Application for a Non-Material Amendment Following a Grant of Planning Permission

Proposed changes to accepted planning permission drawings to show flat roof detail as opposed to pitched roof. Floor plan, site plan, elevations and structural engineers plans/calculations

Description
Proposed Elevations
Drawing Number
4442 51 C

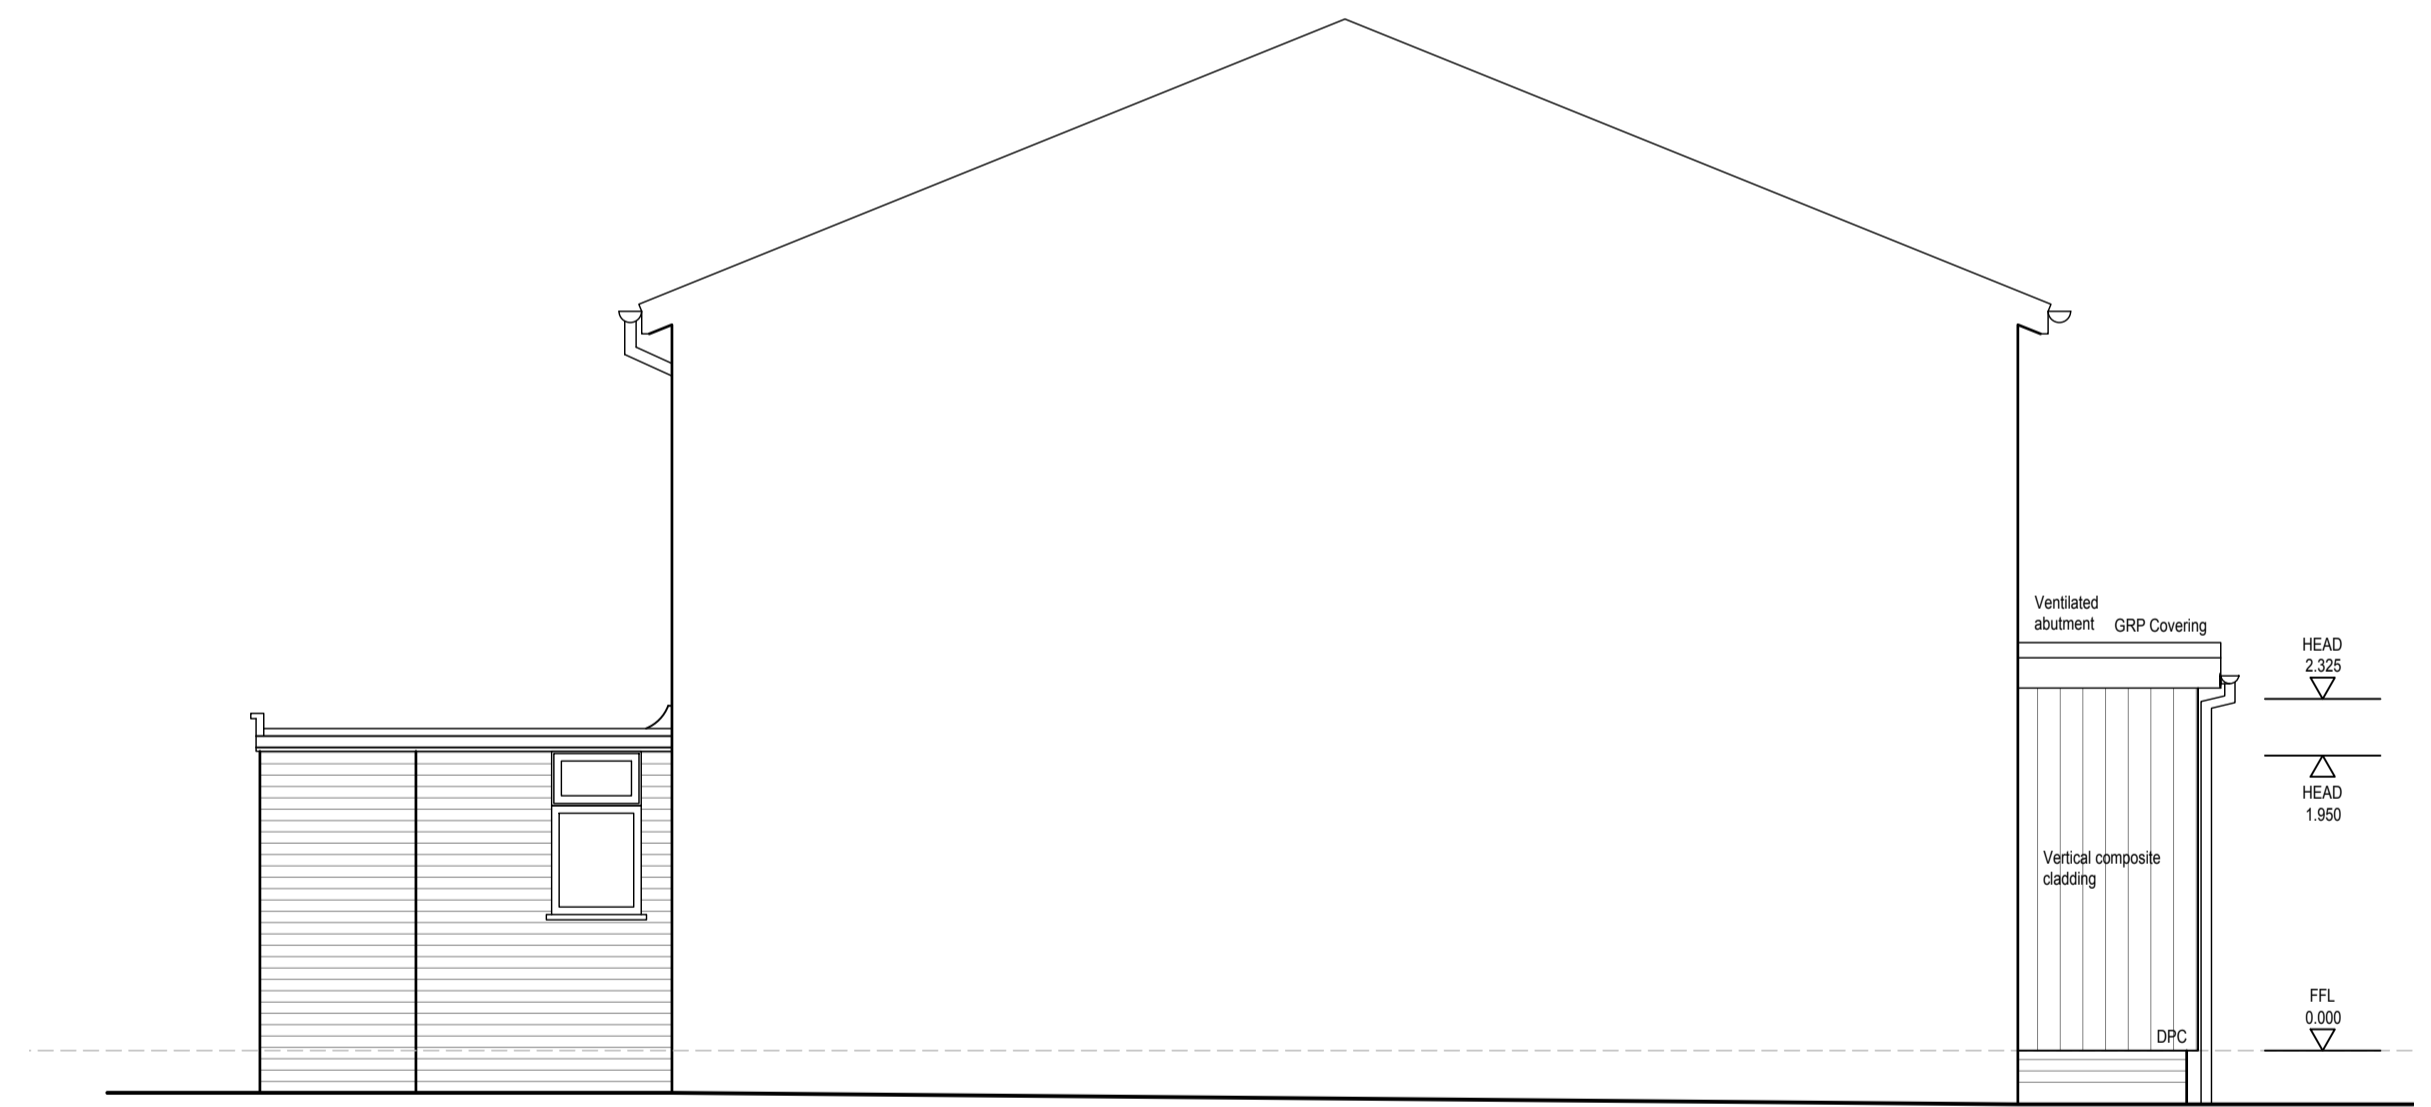
Due to an error from our architects, it was discovered that the proposed design wouldn't work without the replacement of a dining room window to the right of the extension and the subsequent lintels and re cladding that would be involved.

The pitched roof detail then ran over the window, meaning it would look unsightly and prevent the window opening.

Our only viable solution was to switch to a flat roof detail with a glass roof light which would prevent the blocking of the existing window and match other flats roofs around the property. We also believe it will lessen the impact on the street scene as well.
